City of Albuquerque

February 6, 2004

**Re: Ventana Ranch West Subdivision Drainage Management Plan, Addendum 1
Engineer's Stamp dated 12-24-03, (B8/D1)**

EXISTING HYDROLOGY

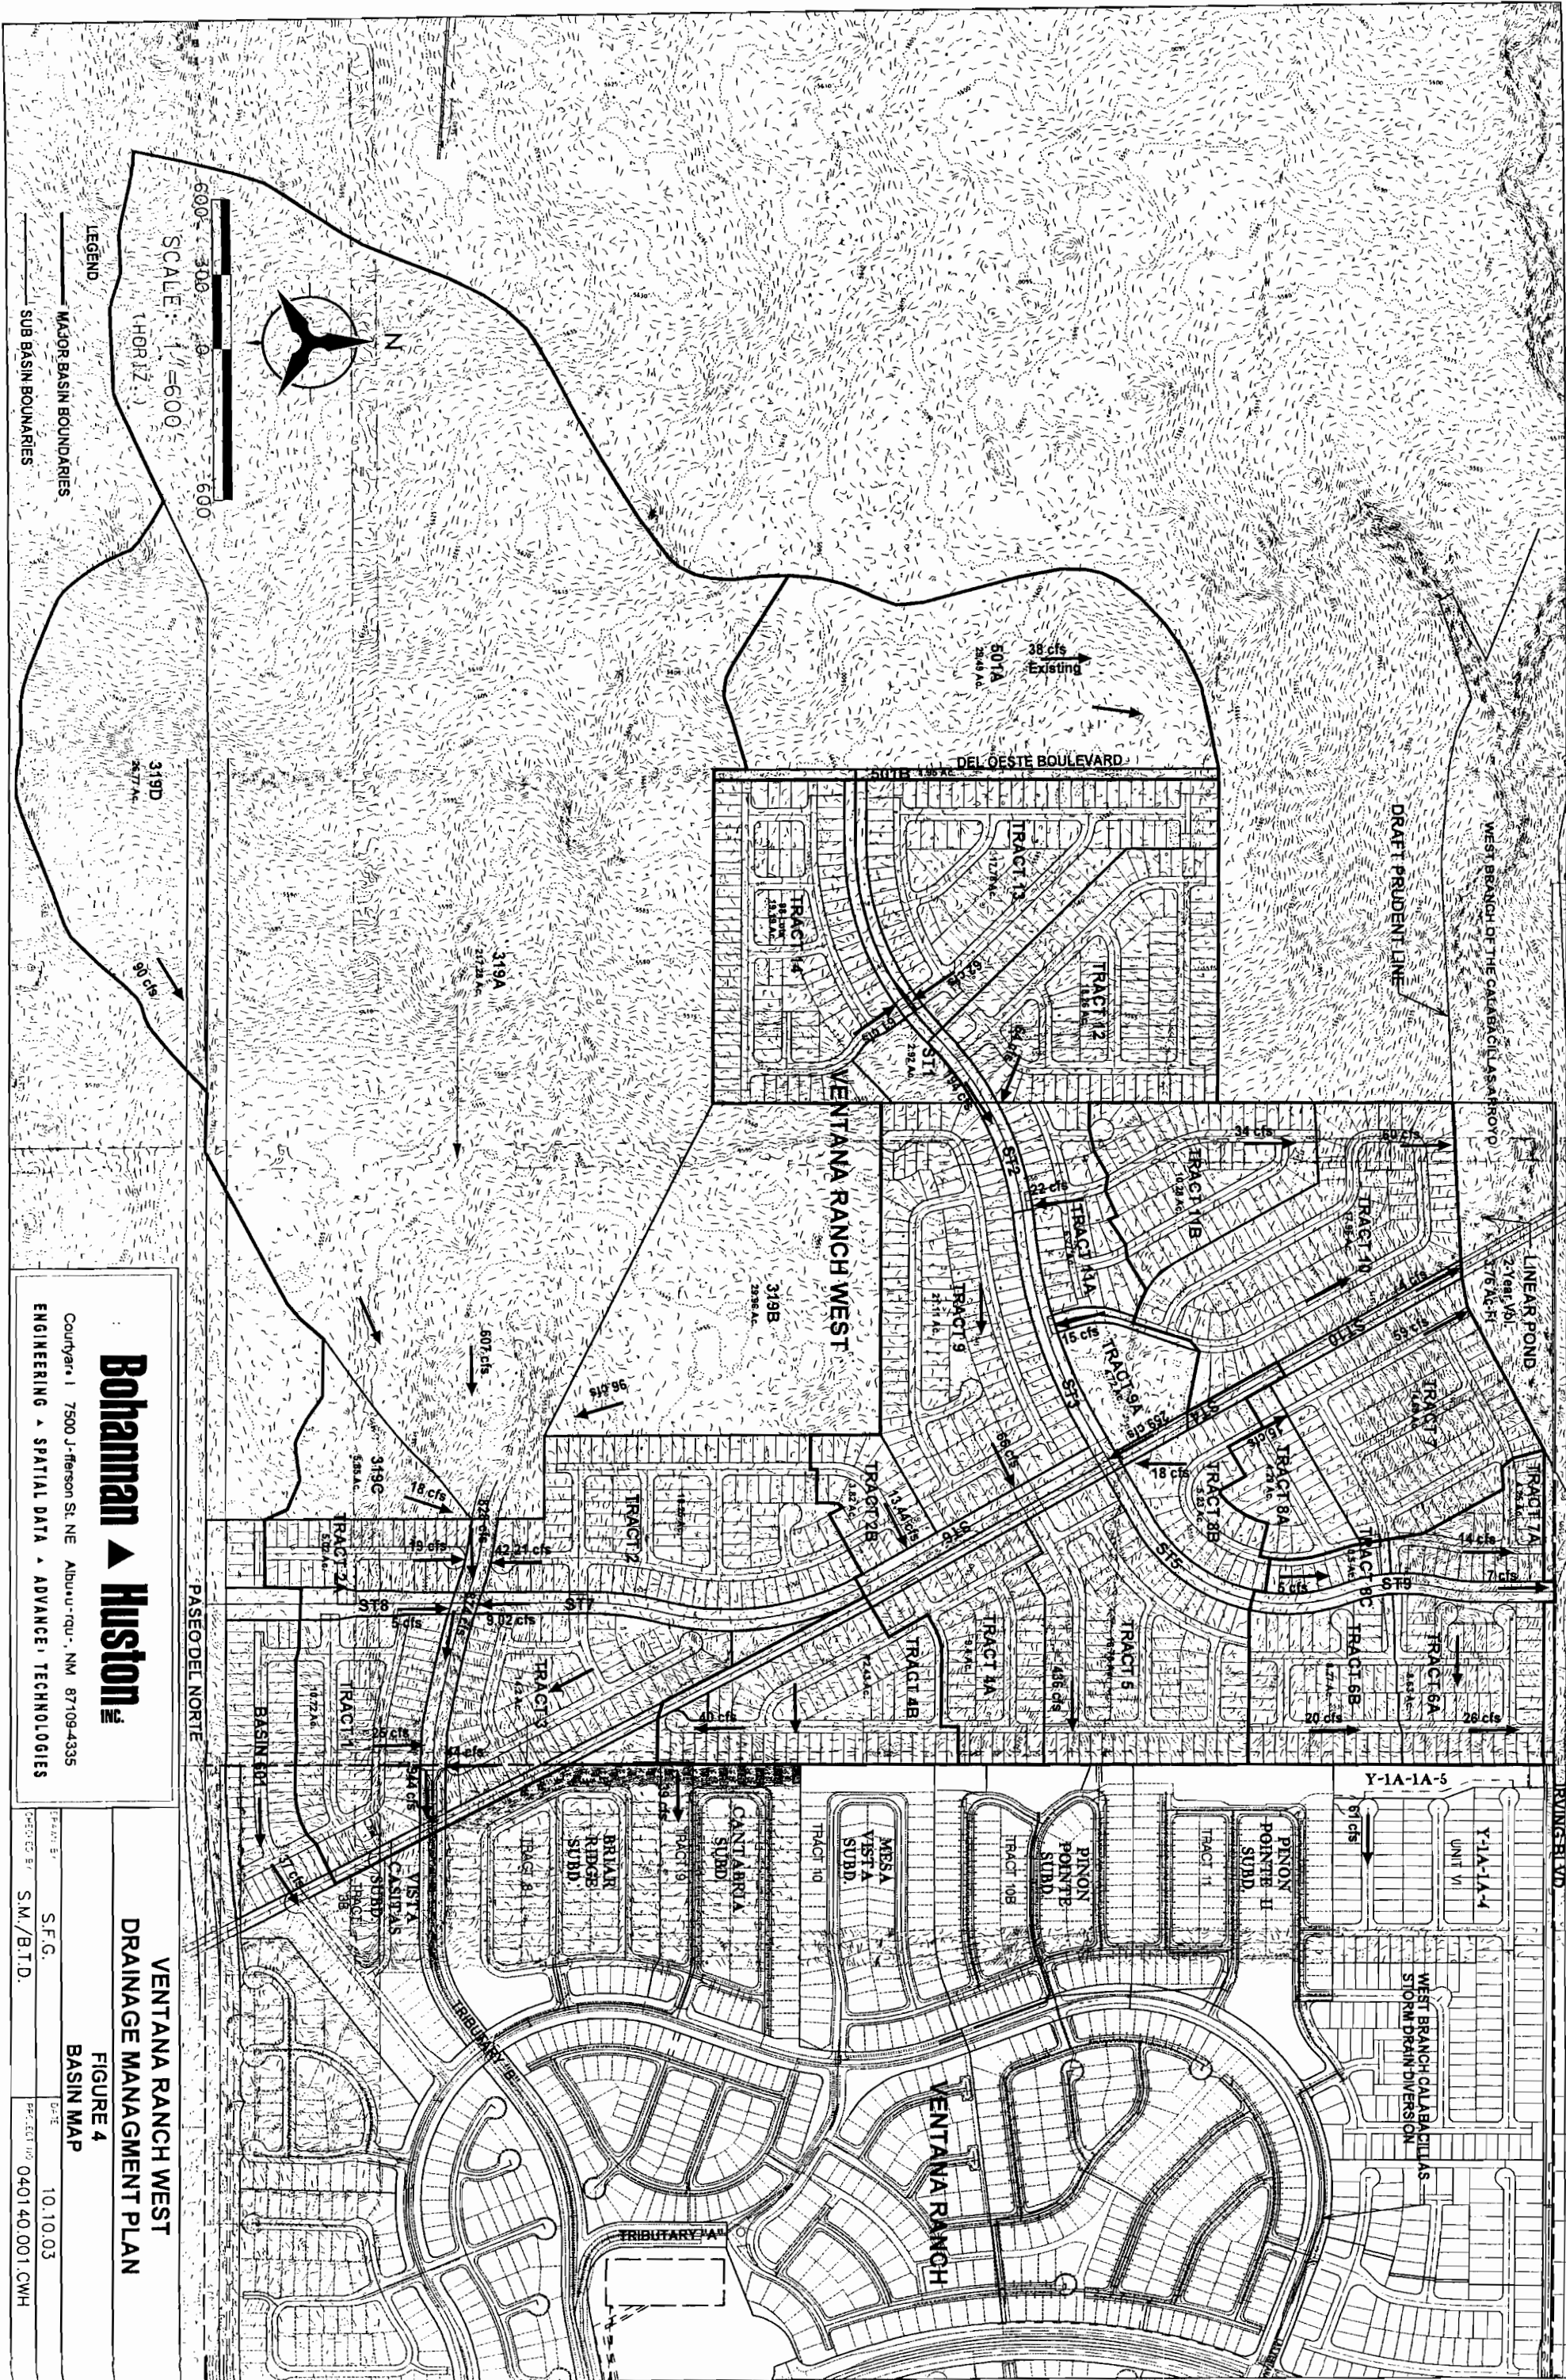
- Please address the area just west of Basin 601 and north of Paseo del Norte. This area must drain through your site as well.
- Please include any existing platting within the boundaries of your upstream basin and include any tract bisected by your developed-basin boundary line in its entirety. It is possible that the offsite runoff may increase.
- The design of your proposed pipe should be for the 944 cfs planned for at eastern edge of the Tracts 1 and 3, not 811 as shown.
